Item No. **Report of the Head of Planning, Building Control, Sport & Green Spaces**

Address 11 WARWICK ROAD WEST DRAYTON

Development: Extension to existing offices at ground floor and creation of two additional floors to create 4 x 1-bed self-contained flats with associated parking.

LBH Ref Nos: **9746/APP/2017/3485**

FRONT ELEVATION EAST

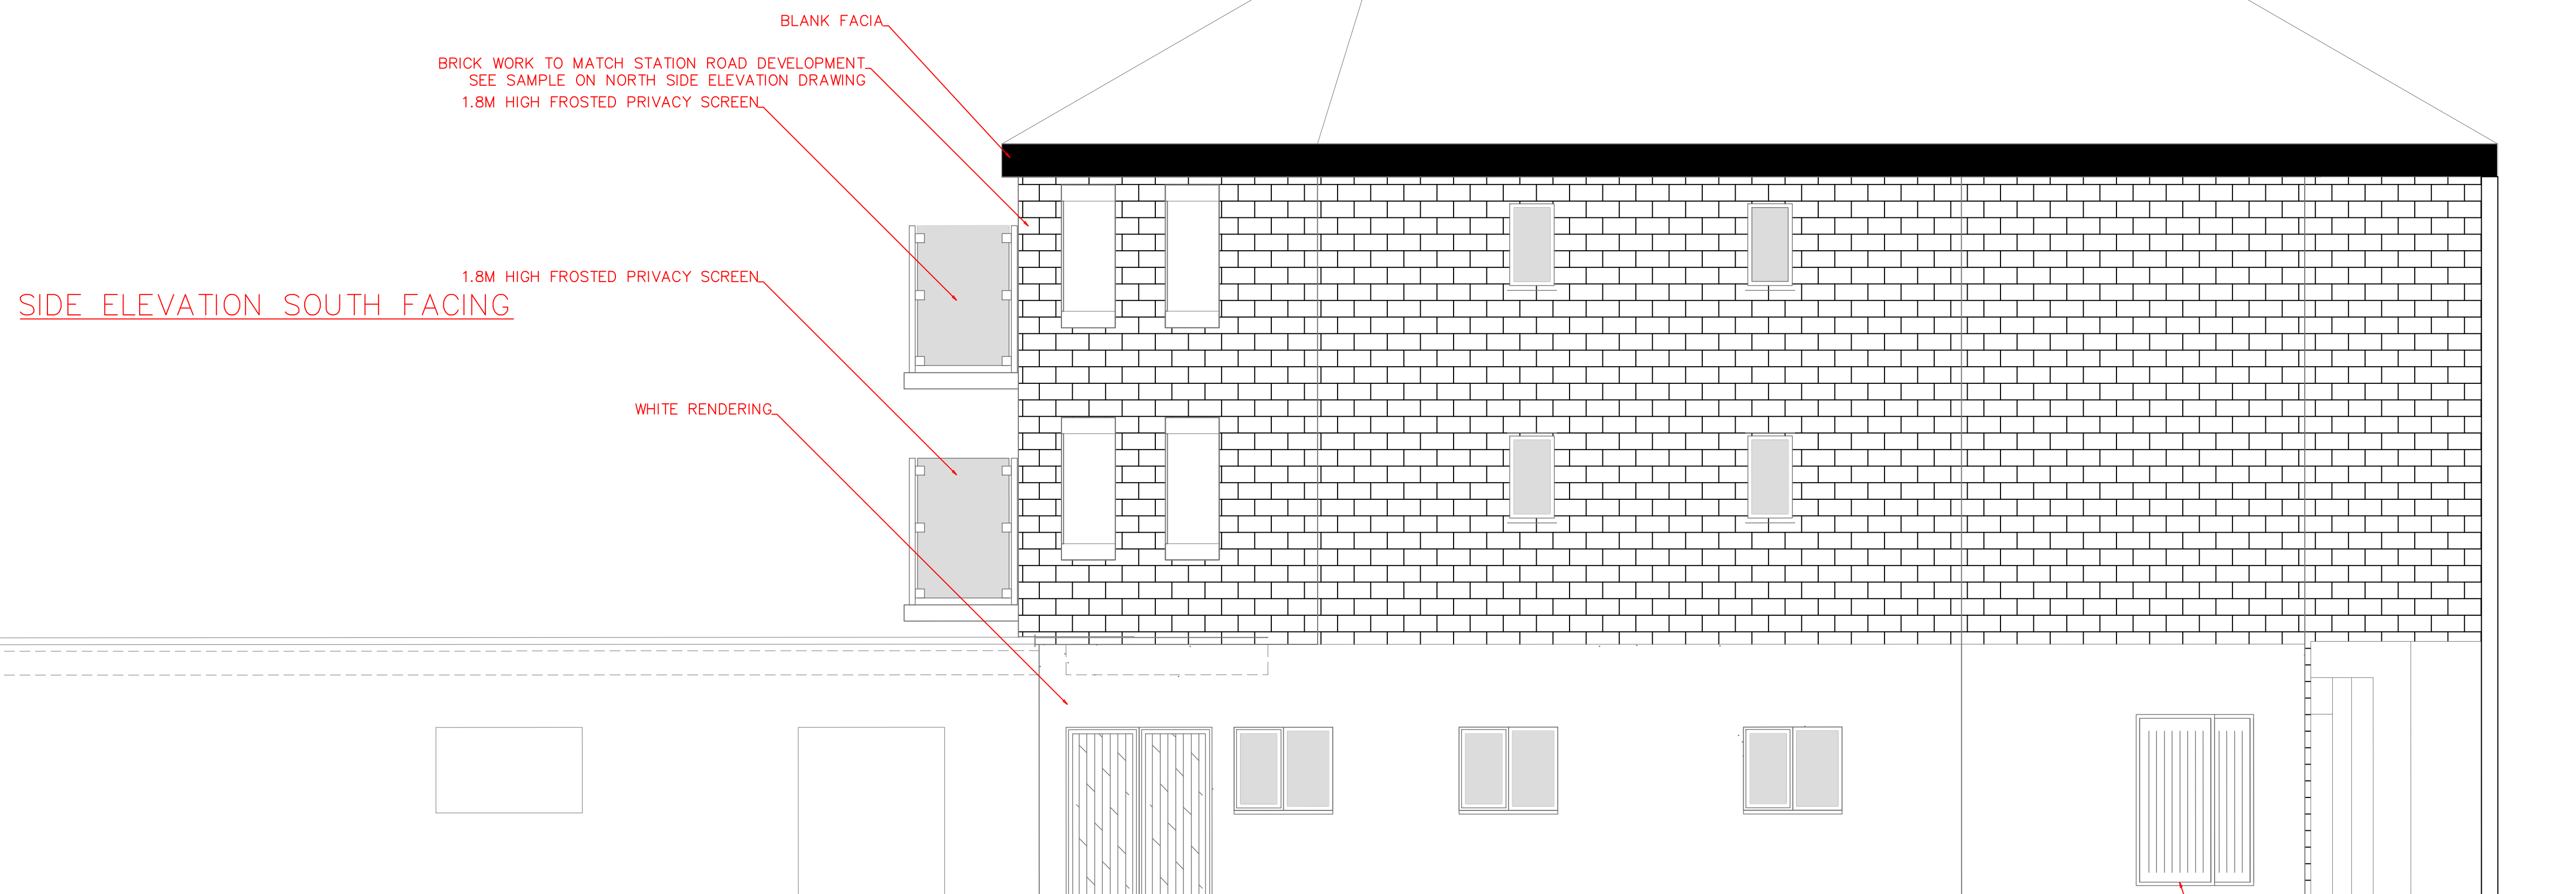
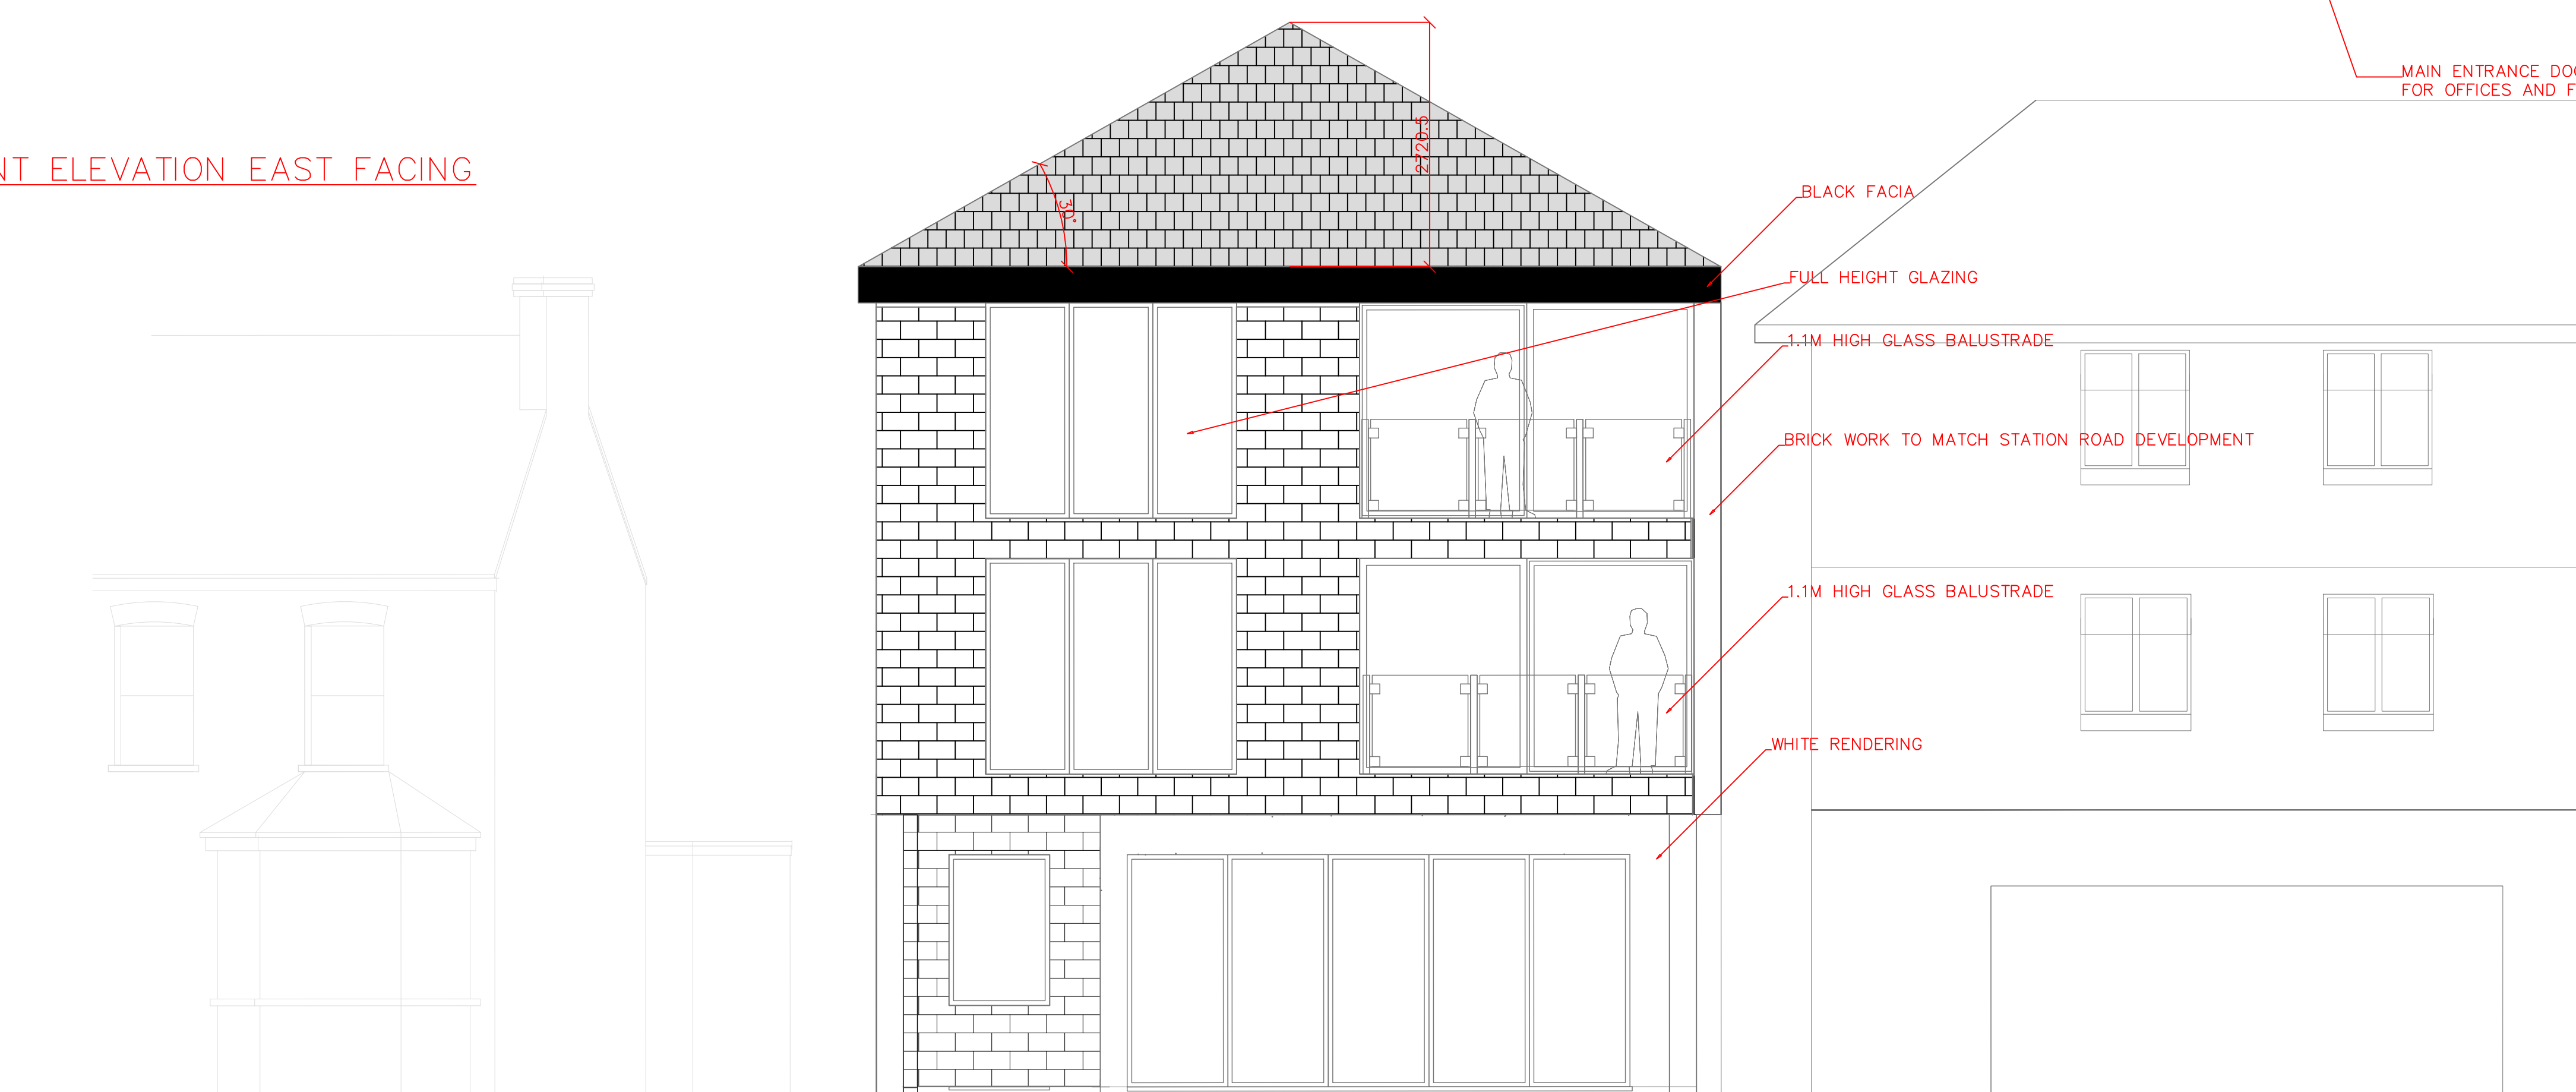
The proposed extended building, by virtue of its excessive, height, scale and bulk would result in a cramped overdevelopment of the site, which would be visually incongruous and overdominant, therefore failing to harmonise with the established character of the surrounding area. The proposal is therefore contrary to Policy BE1 of the Hillingdon Local Plan: Part One - Strategic Policies (November 2012), Policies BE13, BE19, BE21 and BE22 of the Hillingdon Local Plan: Part Two - Saved UDP Policies (November 2012), Policies 3.5 and 7.4 of the London Plan (2016) and the adopted Supplementary Planning Document HDAS: Residential Layouts.

The proposed extended building, by virtue of its excessive, height, scale and bulk would result in an unacceptably oppressive and overbearing form of development which would result in an unacceptable loss of light and outlook to the occupants of Number 9 Warwick Road. As such the proposal would result in an unneighbourly form of development in conflict with policies BE19, BE20 and BE22 of the Hillingdon Local Plan: Part Two -Saved UDP Policies (November 2012).

The adjacent two storey terraced property at Number 9 Warwick Road has rear facing windows serving habitable rooms and bathroom windows in its side elevation. The building has been designed to ensure that the main mass of the building would not breach the 45 degree line from the centre point of the rear facing window serving the habitable room at Number 9 Warwick Road. It is noted that the projecting windows and 1.7 m high privacy screening to the rear facing terrace would however breach this 45 degree line, demonstrating that the additional height and bulk of the building would result in an unacceptably oppressive and overbearing form of development which would result in an unacceptable loss of light and outlook to the occupants of Number 9 Warwick Road. As such the proposal would result in an unneighbourly form of development in conflict with policies BE19, BE20 and BE22 of the Hillingdon Local Plan: Part Two -Saved UDP Policies (November 2012).

On Warwick Road, there is a mixed height and form of building with the two storey terraced housing to the South, and 3 storey building opposite with a 4 storey building under construction to the North. The applicant considers that the building height (9.25 m) is designed to relate to the neighbouring Victorian property and not overpower it, whilst also fitting within the larger masses of the new build development on the remaining boundaries. Concerns were raised during consideration of the pre-application submission that the overall scale, height and bulk of the building (especially the eaves height) would dominate the adjacent Victorian terrace. This current submission is for a taller building in that the flat roof would project 0.8

m above the ridge of the adjacent terrace with the eaves being sited 3 m above the eaves of the adjacent terraced property at Number 9 Warwick Road. As such the proposal would result in a cramped overdevelopment of the site, which would be visually incongruous and overdominant, therefore failing to harmonise with the established character of the surrounding area. The proposal is therefore contrary to Policy BE1 of the Hillingdon Local Plan: Part One - Strategic Policies (November 2012), Policies BE13, BE19, BE21 and BE22 of the Hillingdon Local Plan: Part Two - Saved UDP Policies (November 2012), Policies 3.5 and 7.4 of the London Plan (2016) and the adopted Supplementary Planning Document HDAS: Residential Layouts.

REAR ELEVATION WEST FACING

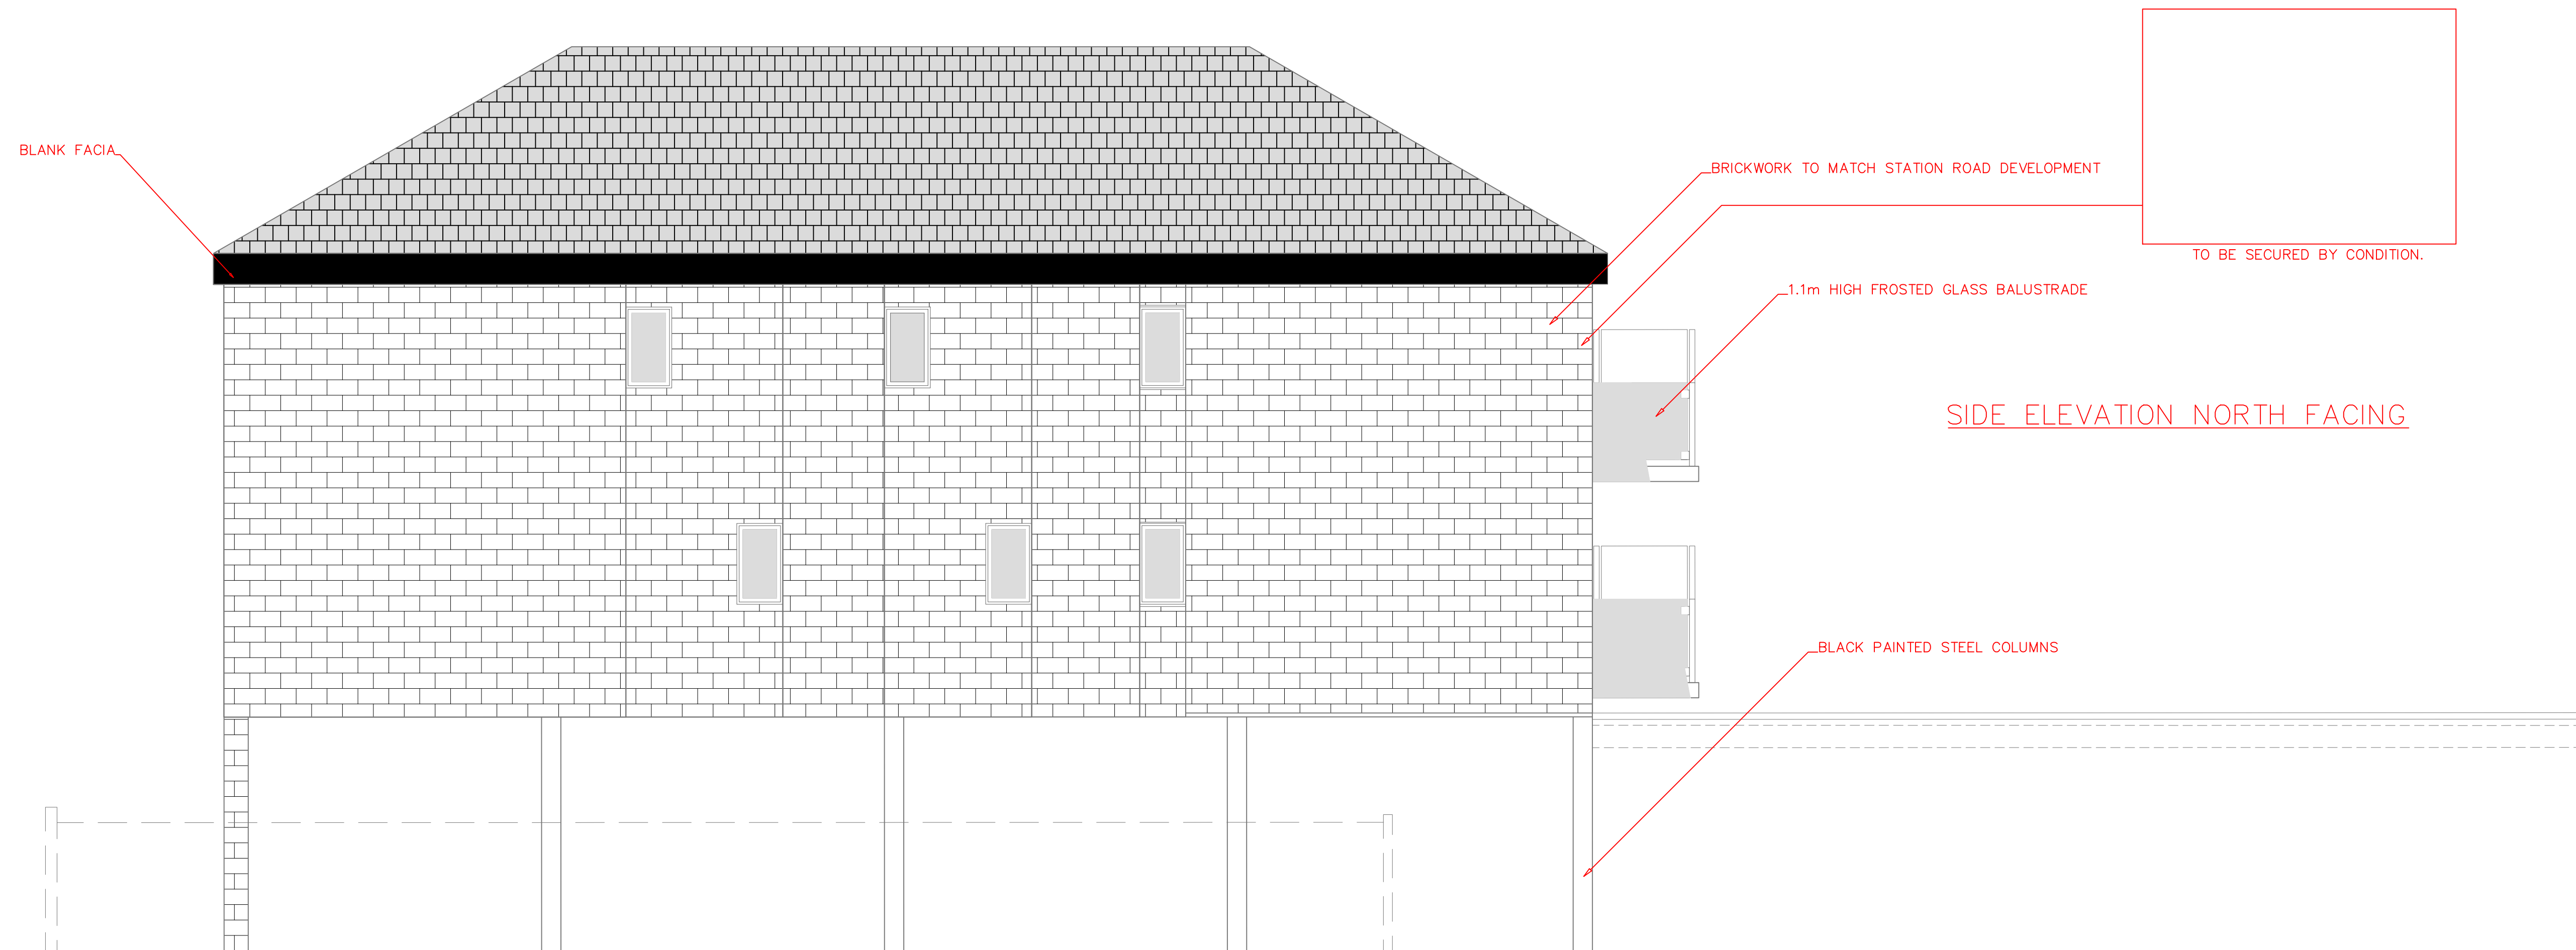
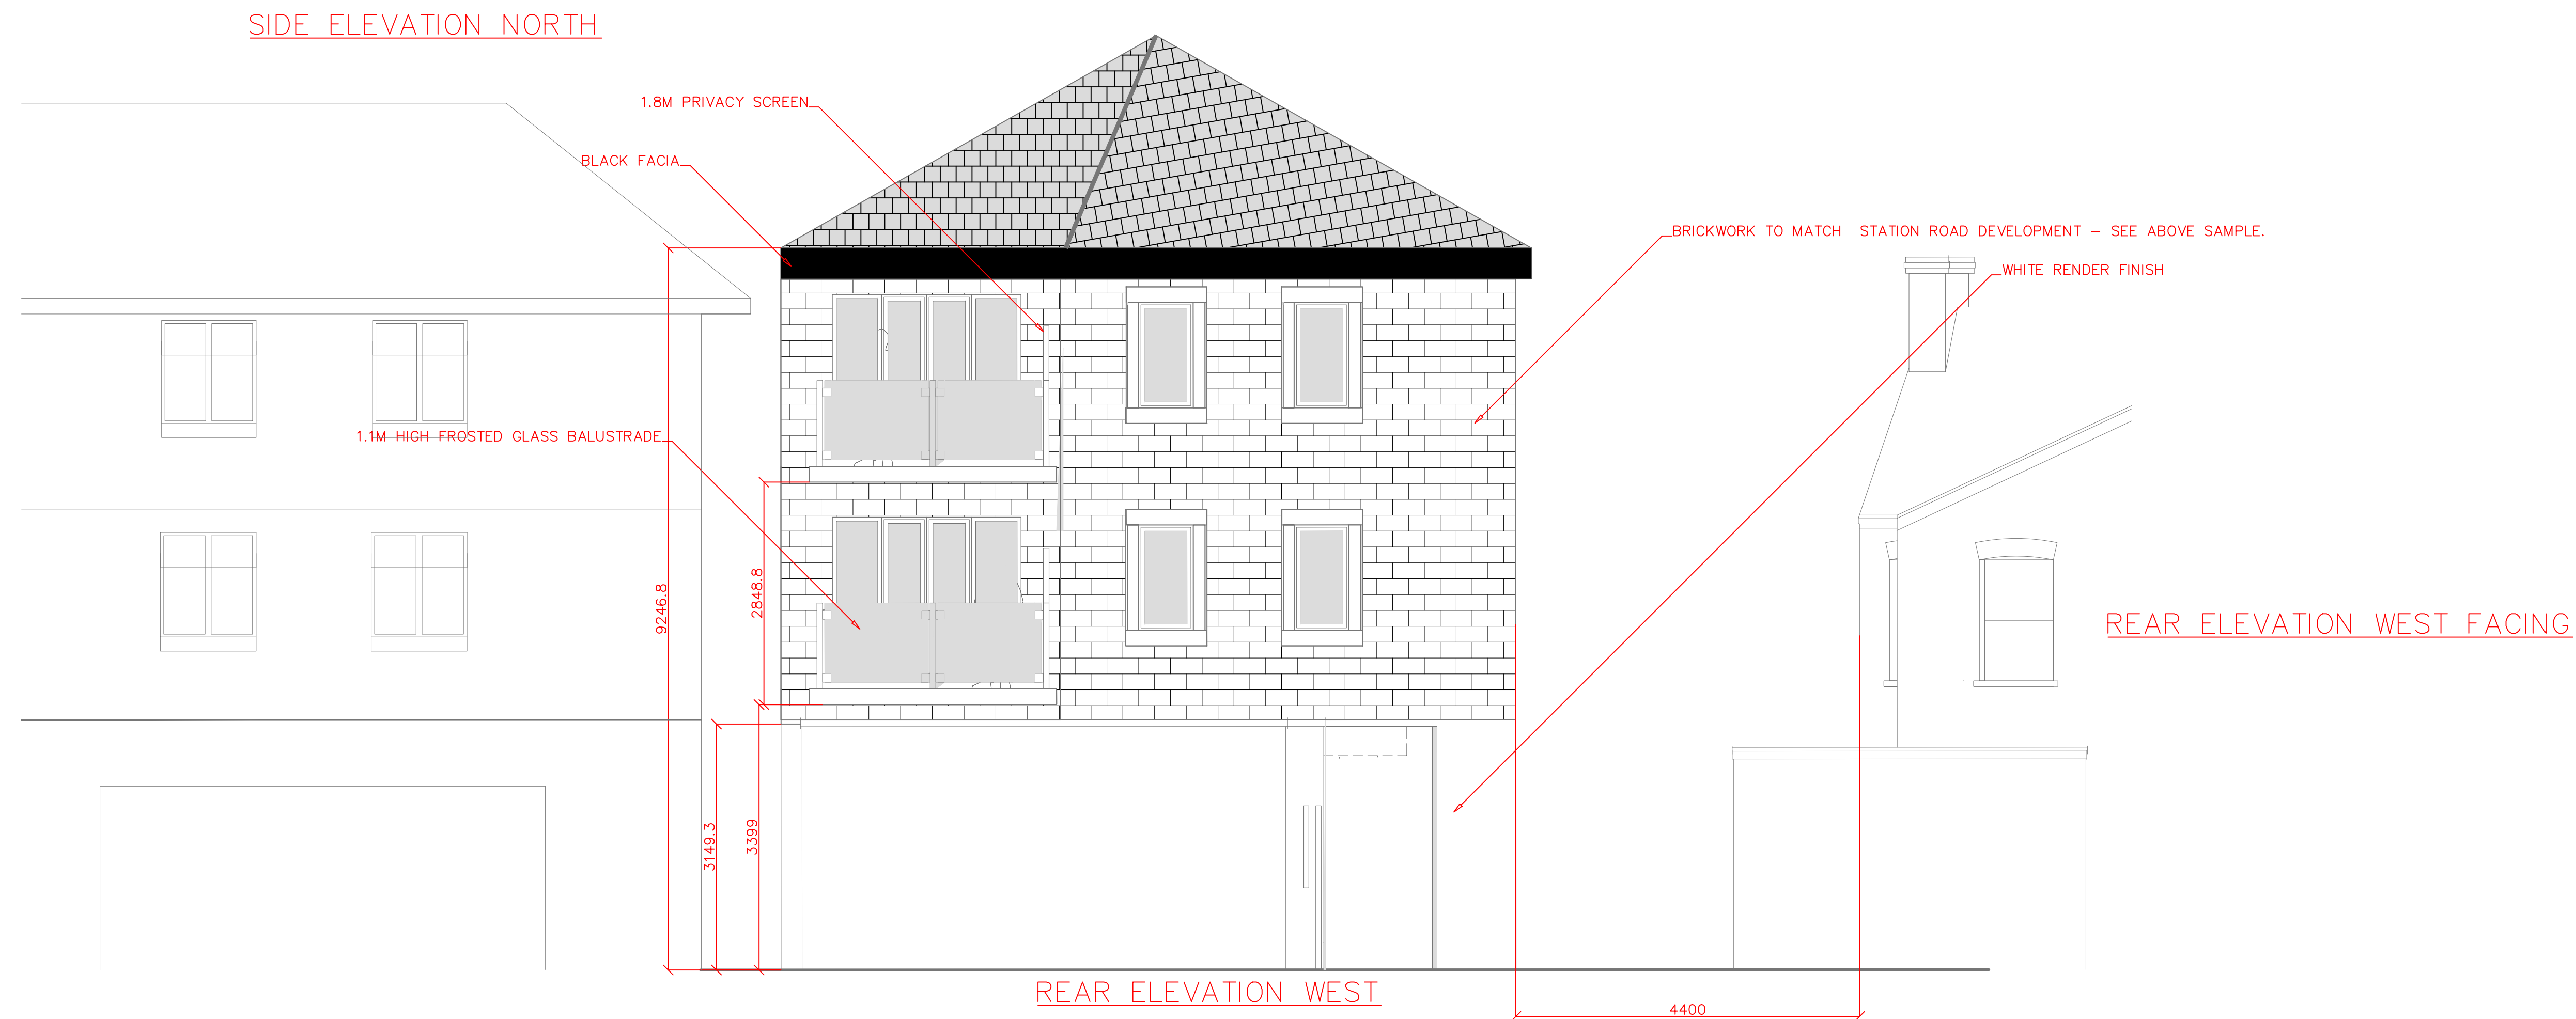
The submitted plans indicate that the side facing windows would be obscure glazed and fixed shut which, in the event of an approvable scheme, could be conditioned to ensure that there was no unacceptable loss of privacy in accordance with Policy BE24 of the Local Plan.
